**Consultation Response from KC,  
Highways Development Management**

**2026/90704 7, Wadsworth Court, Cleckheaton, BD19 3UN**

**Alterations to intergral garage and erection of bay window to extend living accommodation,  
internal and external alterations**

**Date Responded: 21<sup>st</sup> April 2026**

PROPOSED GROUND FLOOR PLAN

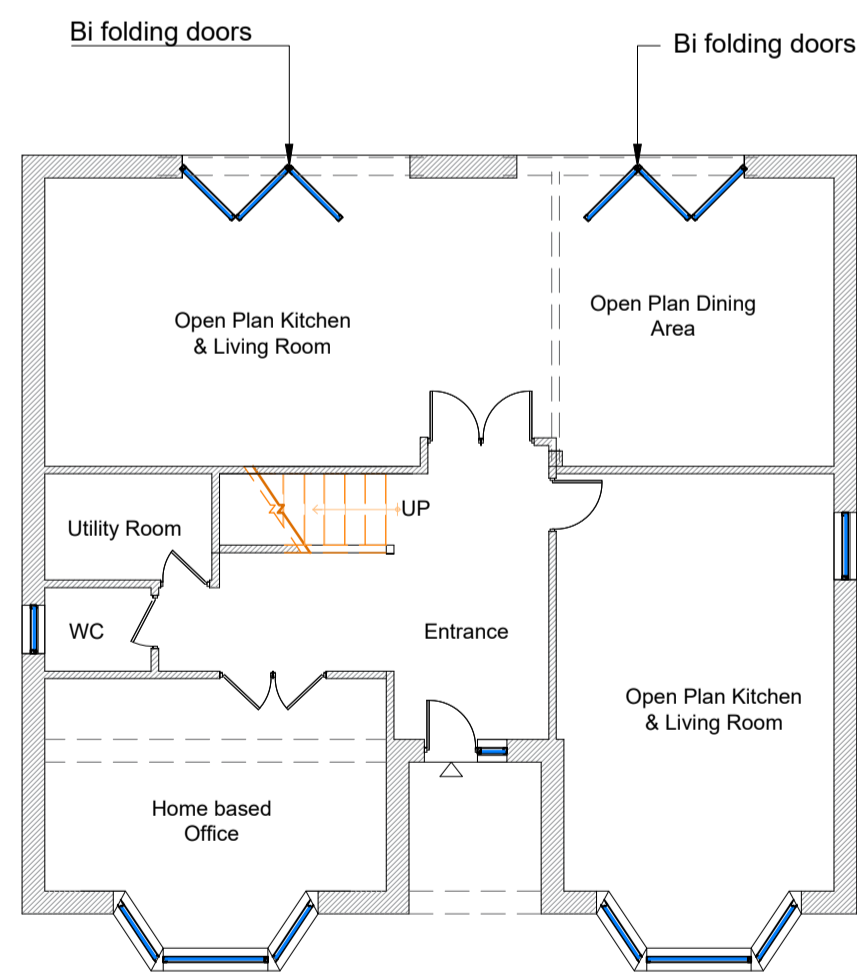
Whilst the existing garage would be lost, it is of a smaller dimension typical of current criteria and vehicle sizes. It is doubtful whether it was used to date for car parking in its entirety. Instead, more likely used for storage which could include cycle parking.

For car parking, there are to be two retained exterior parking spaces plus space to park another vehicle in the vicinity of the property and within the red line should the need arise without significant loss of turning space. This would allow for at least three car parking spaces to accord with the advisory within the Kirklees Highway Design Guide SPD of three spaces for four plus bedroomed dwellings and a degree of flexibility referenced within the Kirklees Local Plan Policy 22. The current dwelling is understood to have five bedrooms.

Replacement storage should be considered and is desirable for cycle parking. Also desirable is the provision of an electric vehicle charging point.
